# CITY OF ALBUQUERQUE

January 31, 2019

RE: **1<sup>st</sup> Nations Community Healthsource**  
**5608 Zuni SE**  
**Revised Grading and Drainage Plan**  
**Engineers Stamp Date: 1/15/19**  
**Drainage File: L18D047**

C-100

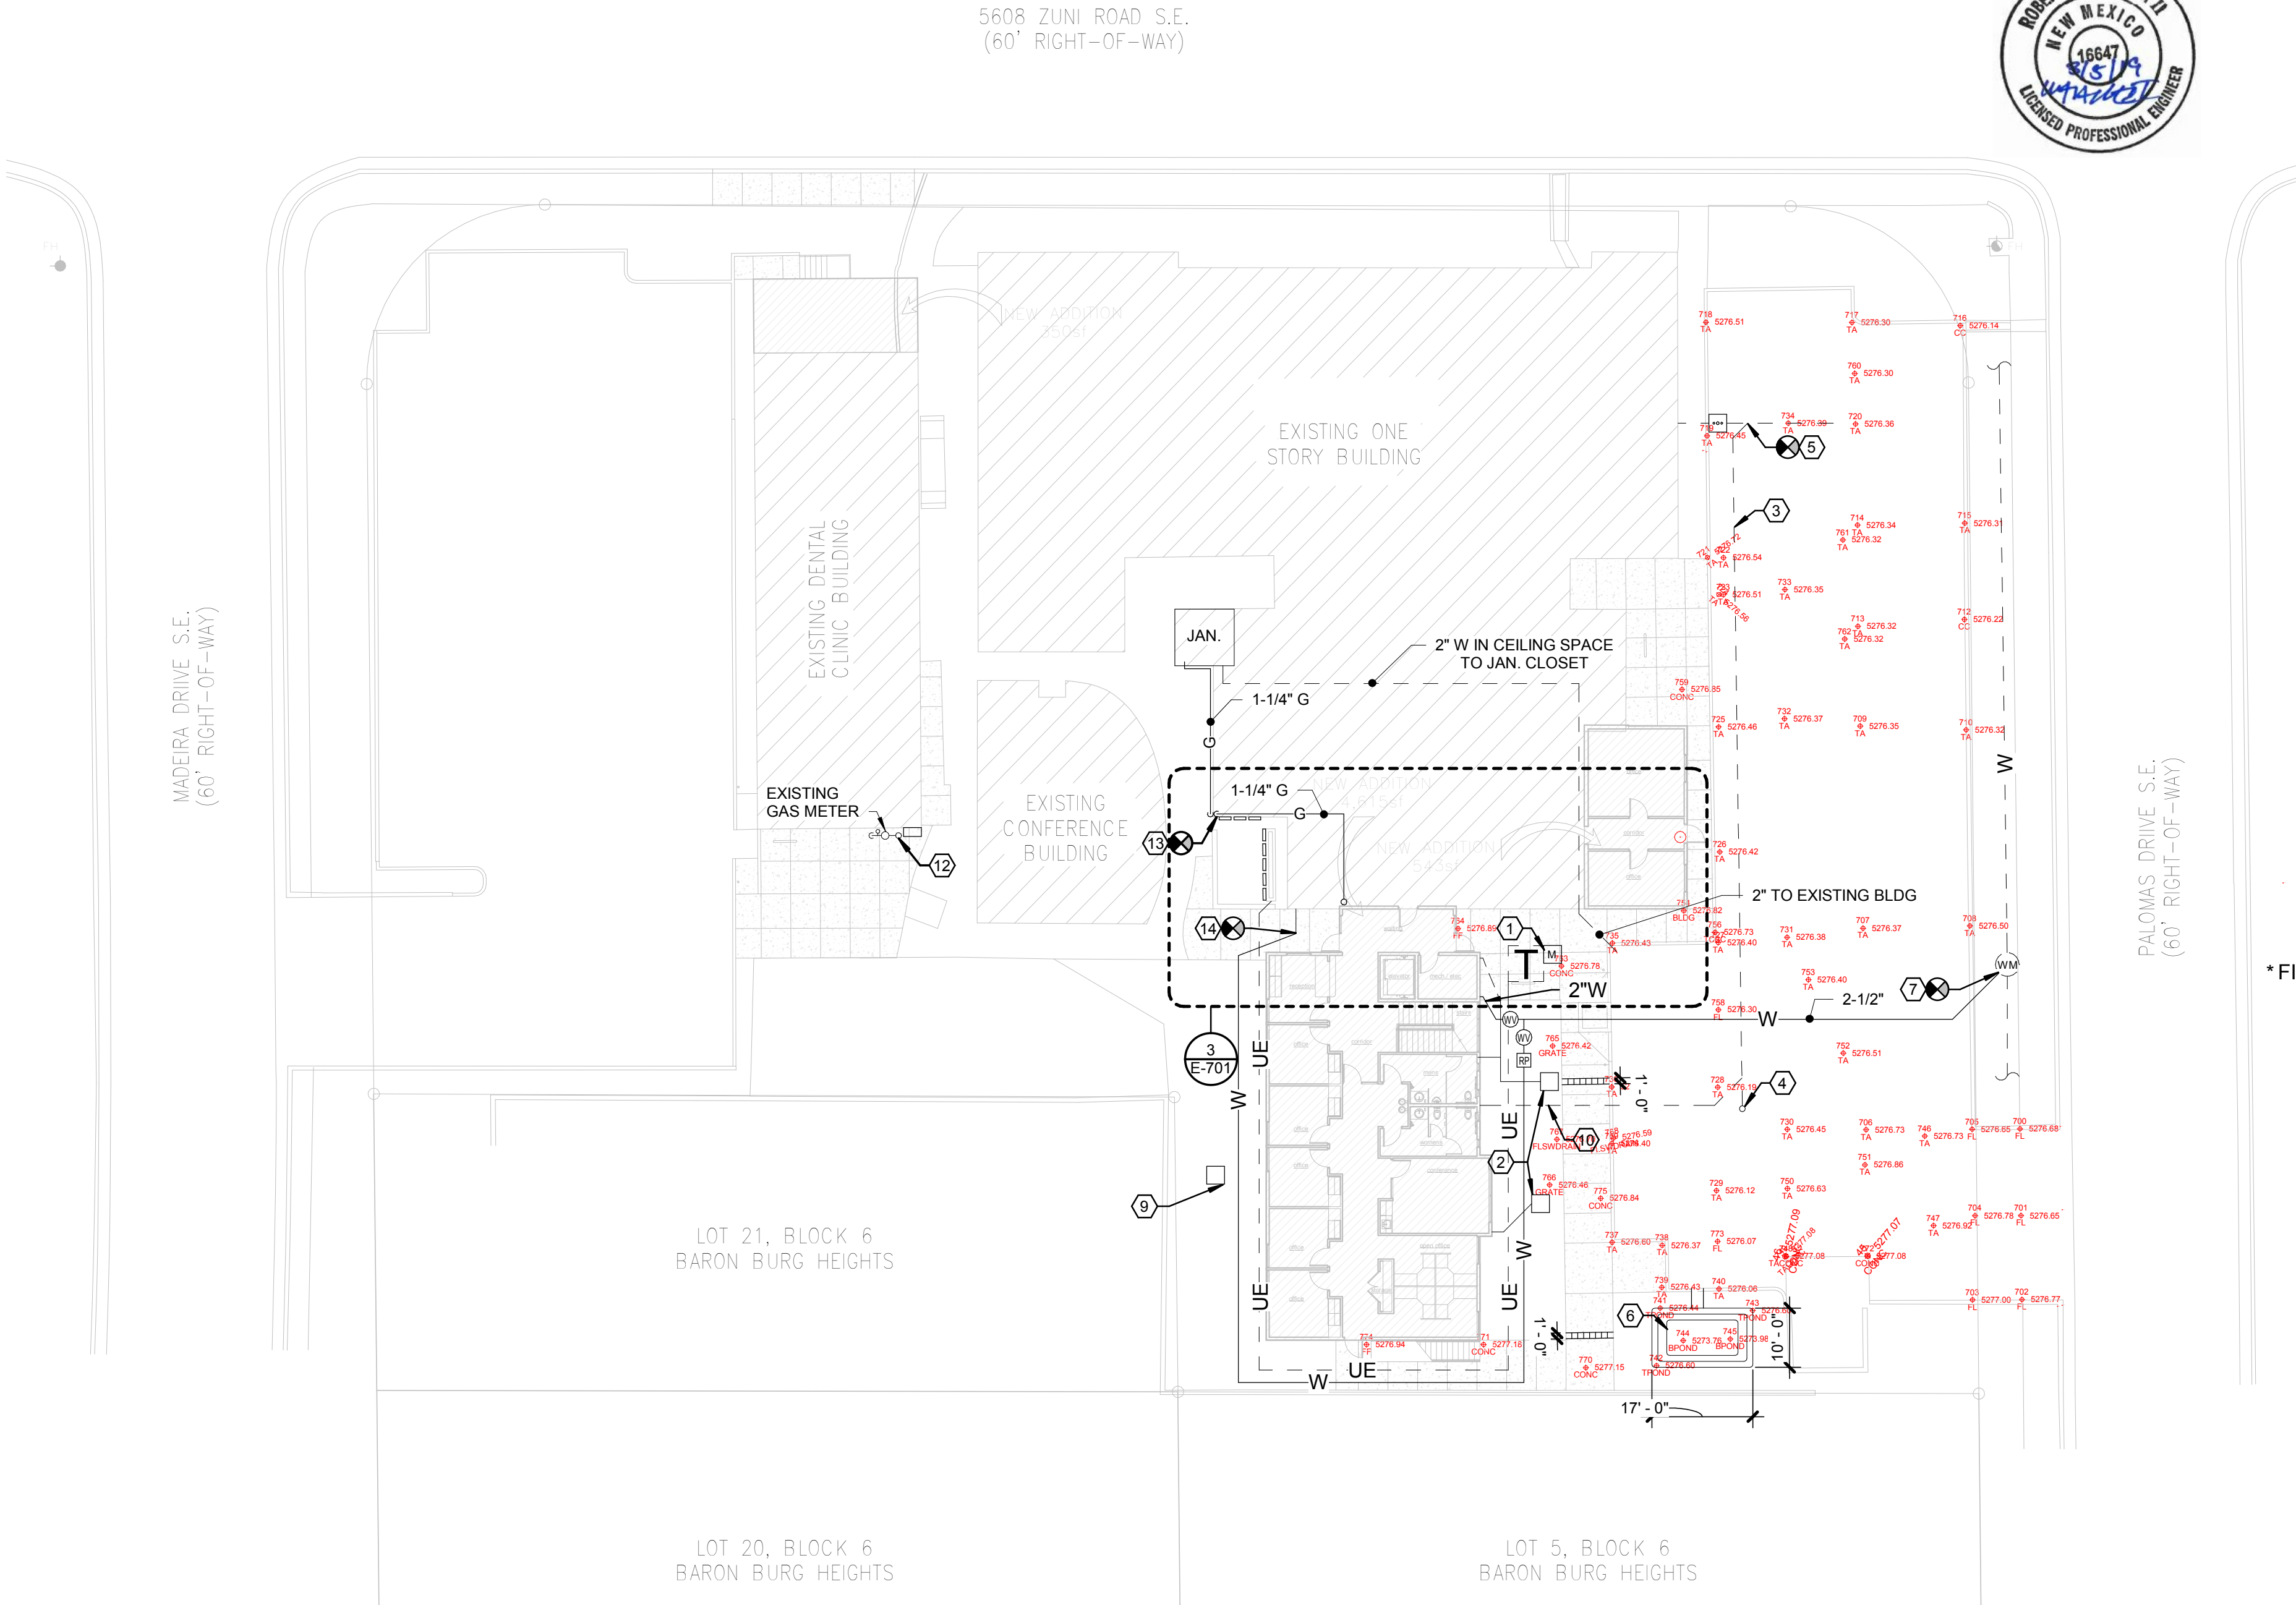
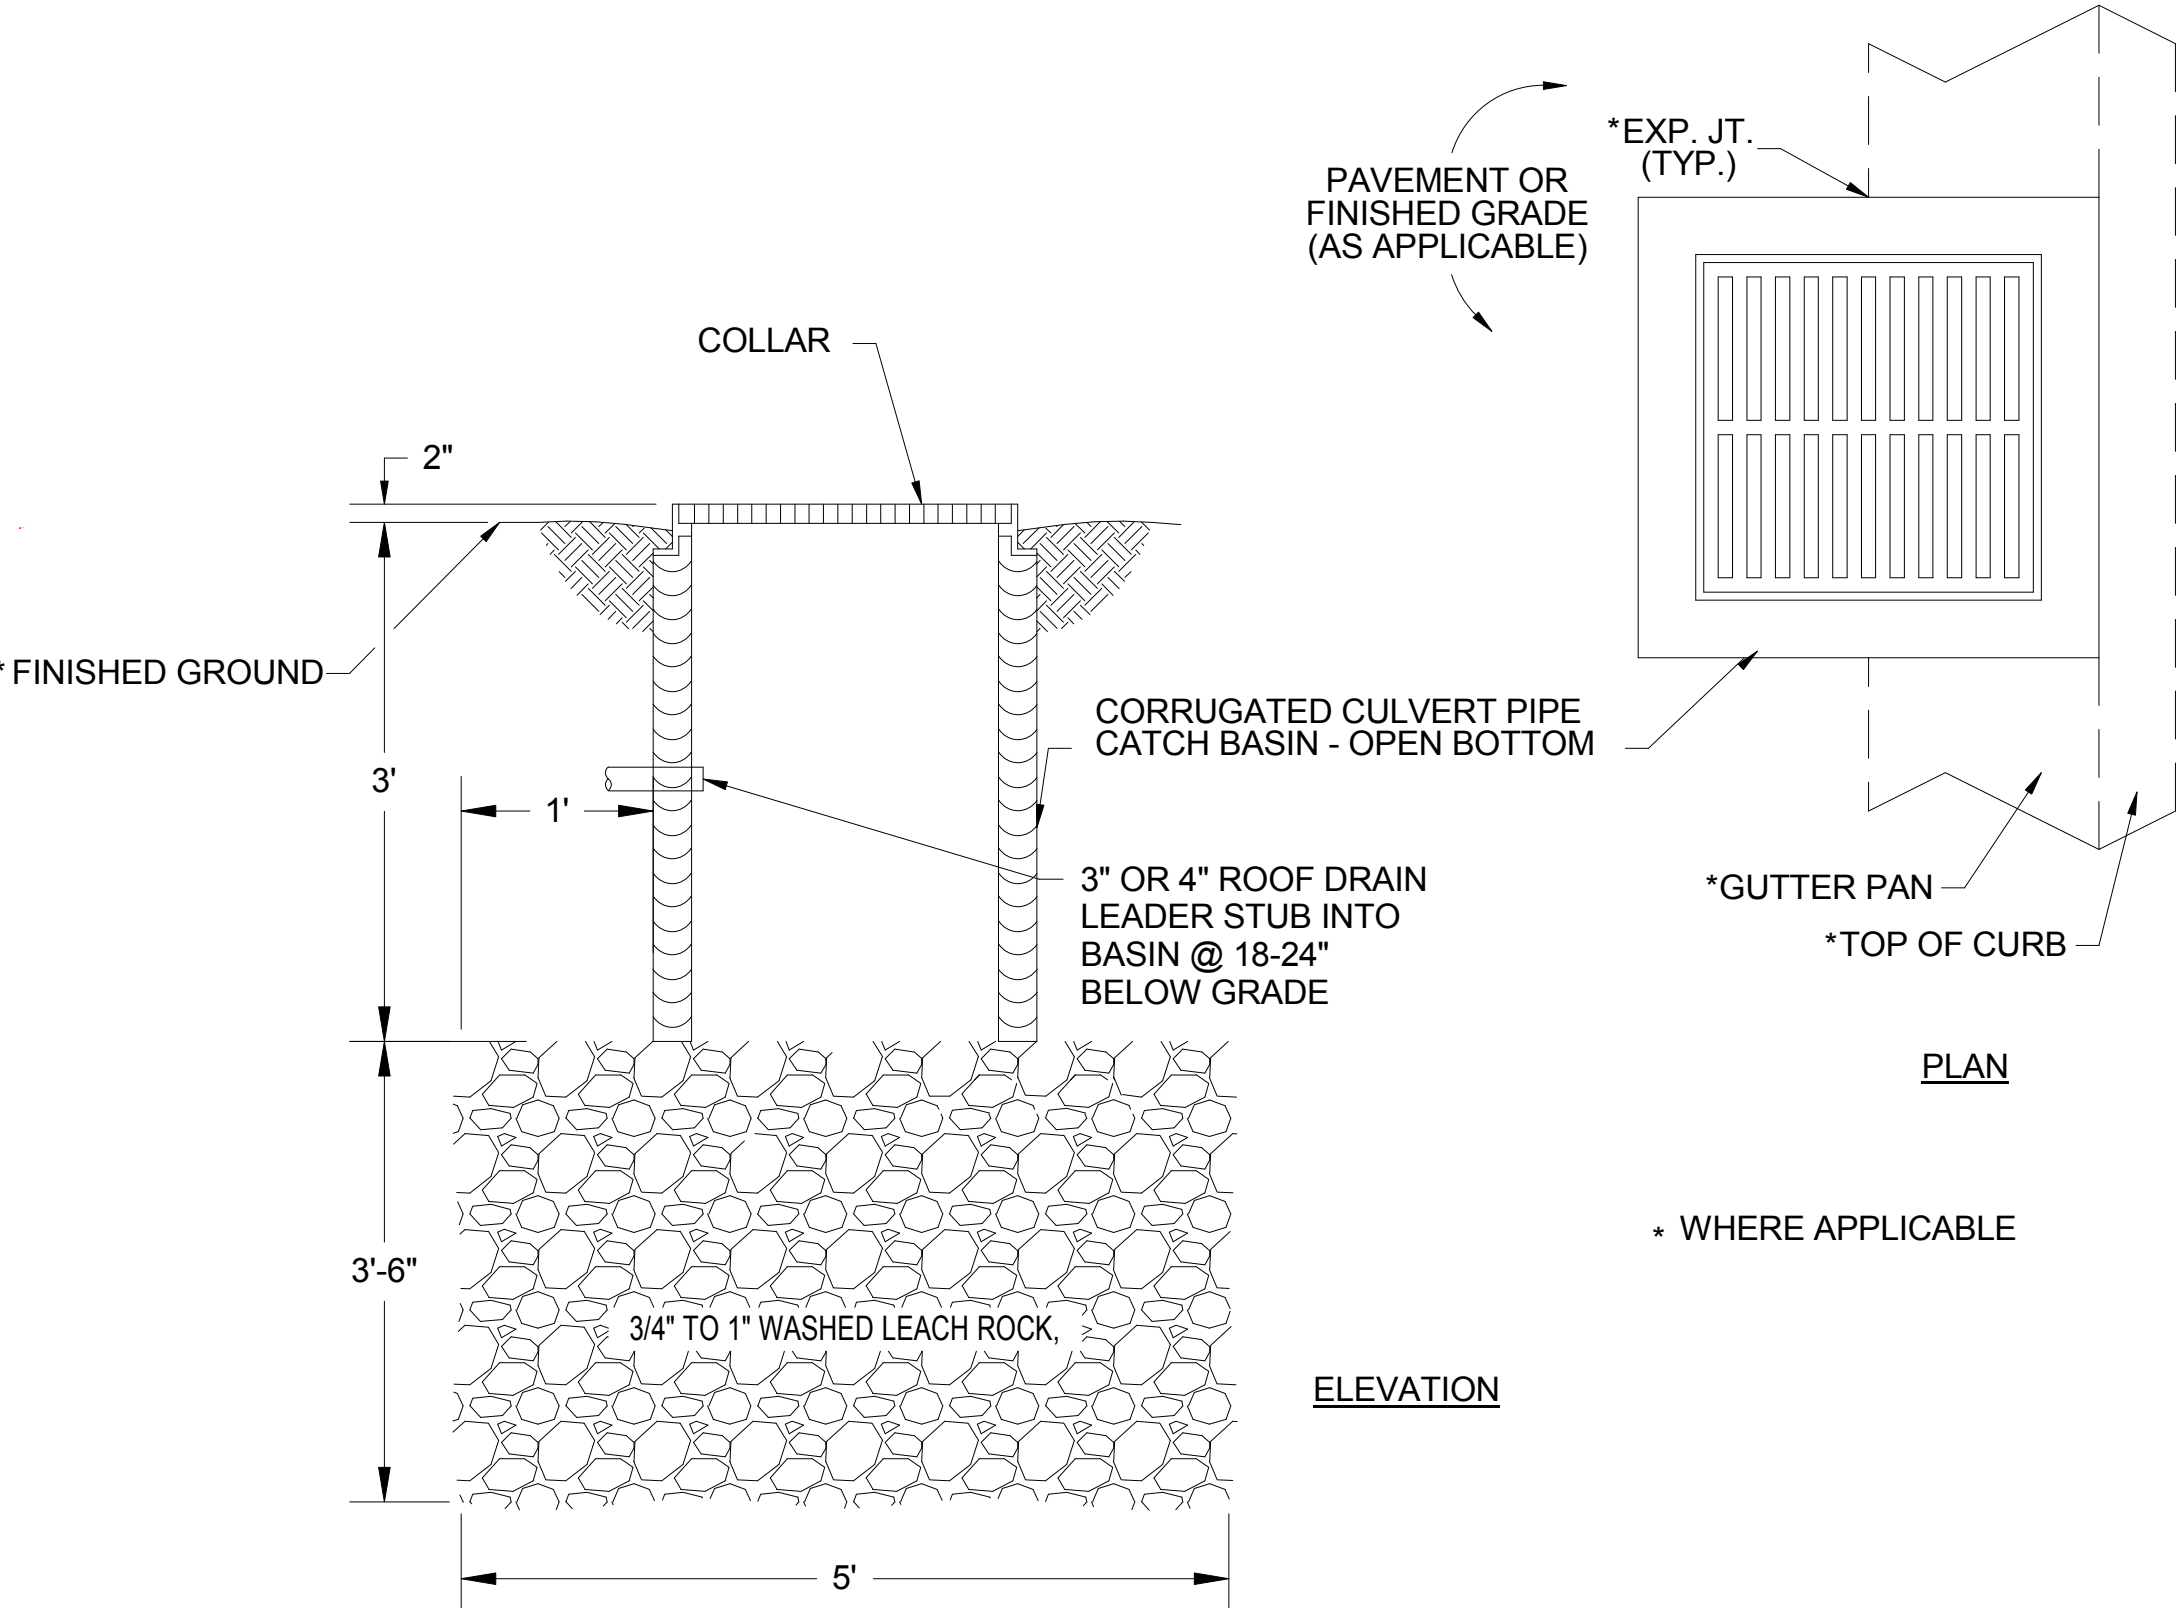
4. Payment of the Fee in Lieu (Amount =  $207\text{CF} \times \$8/\text{CF} = \$1656$ , per sheet C-002) of onsite management of the SWQV must be made. Include a copy of the paid receipt when resubmitting.
